3049 Executive Parkway Suite 200
Lehi UT 84043
gosolo.io
(888) 316-5845

Date: 8/10/2023

Project Address: 635 Lenoir Dr, Spring Lake NC

Outlined below are the list of rejections received from the plan checking department. Each revision item has a response, outlining our corrective action for your rejection, these will be marked in red in this letter and will also have red revision clouds on the permit packet/plan set. If you have any questions, please reach out to the submitting entity/company, or in some cases, this may be Solo.

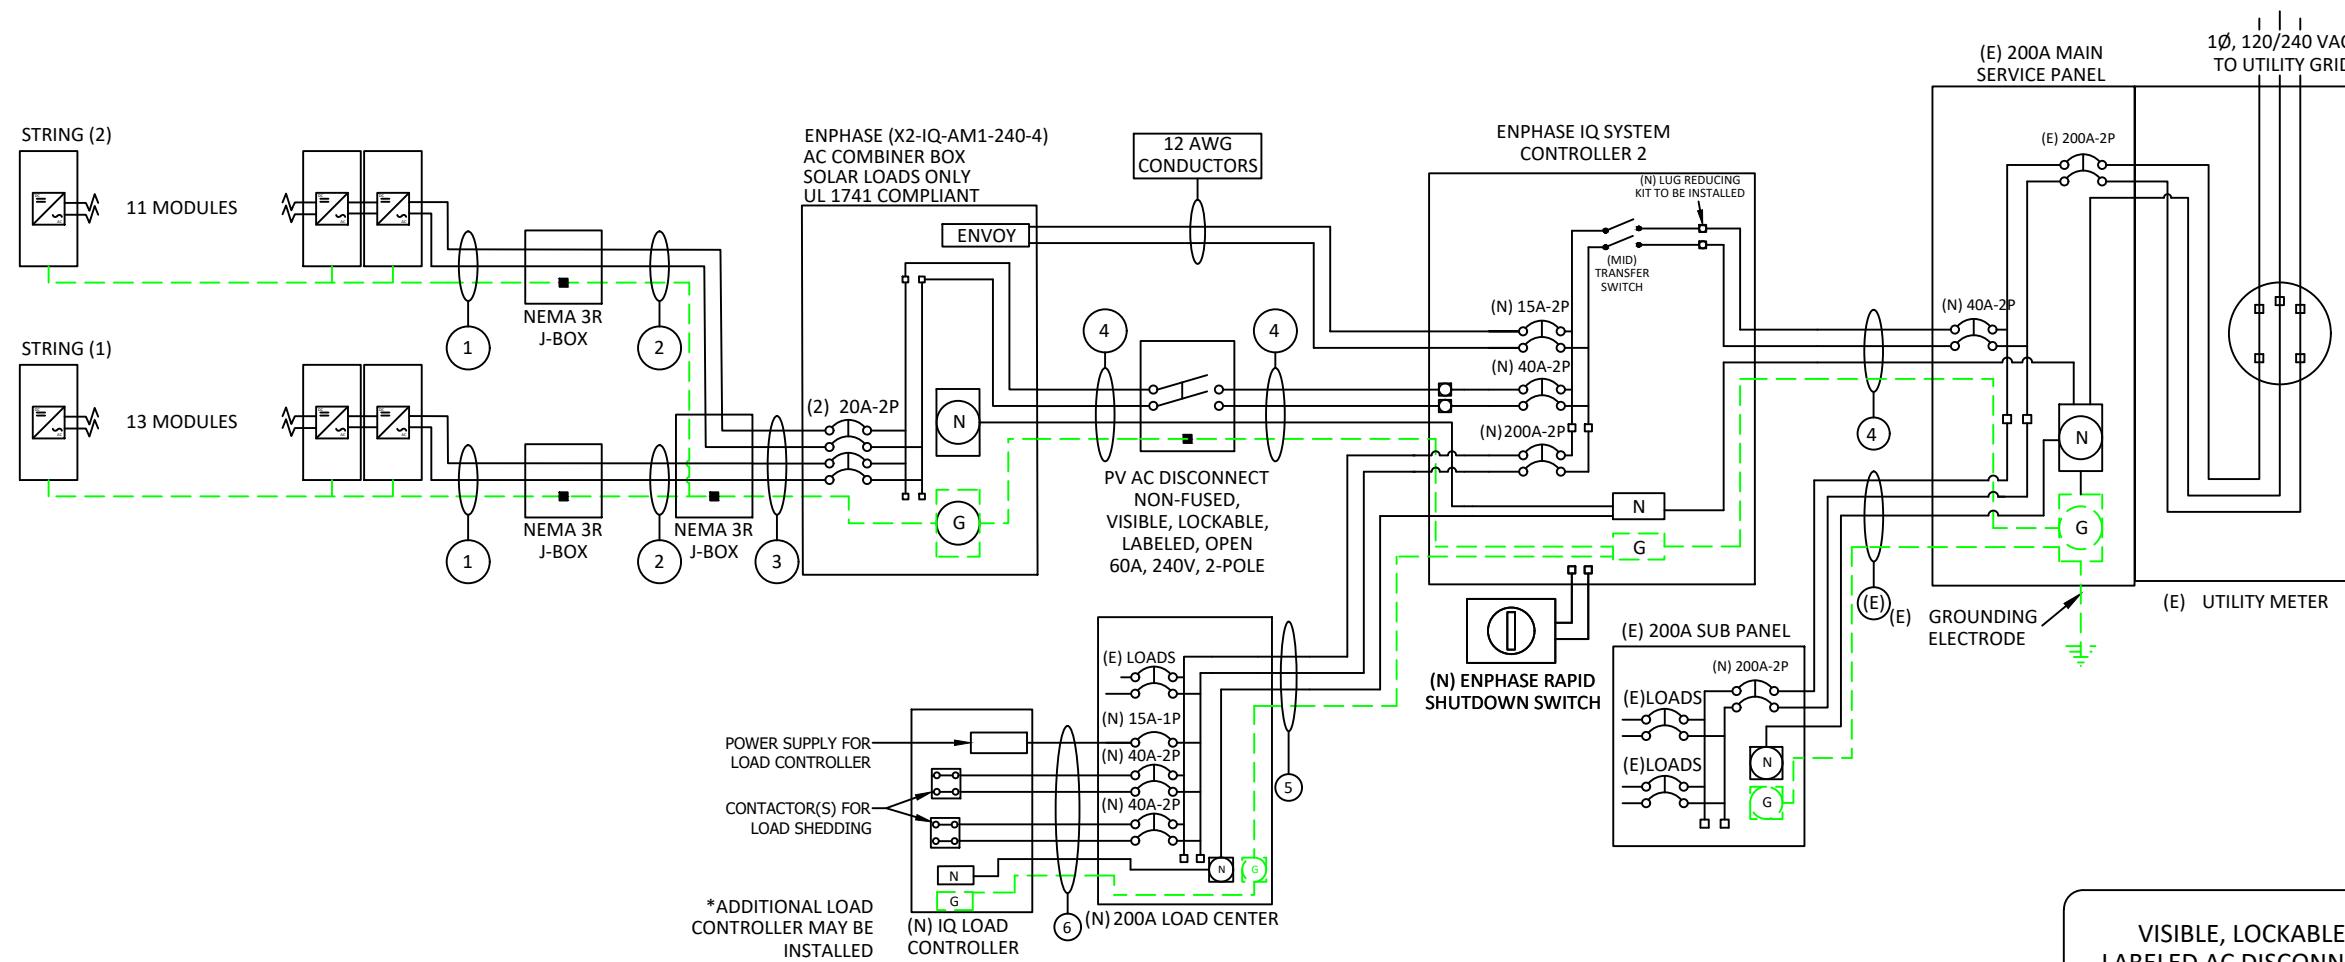
1) Questions about the line diagram.

- We are adding a main breaker to the existing sub panel and we are installing a new load center that will contain some relocated loads for back up.
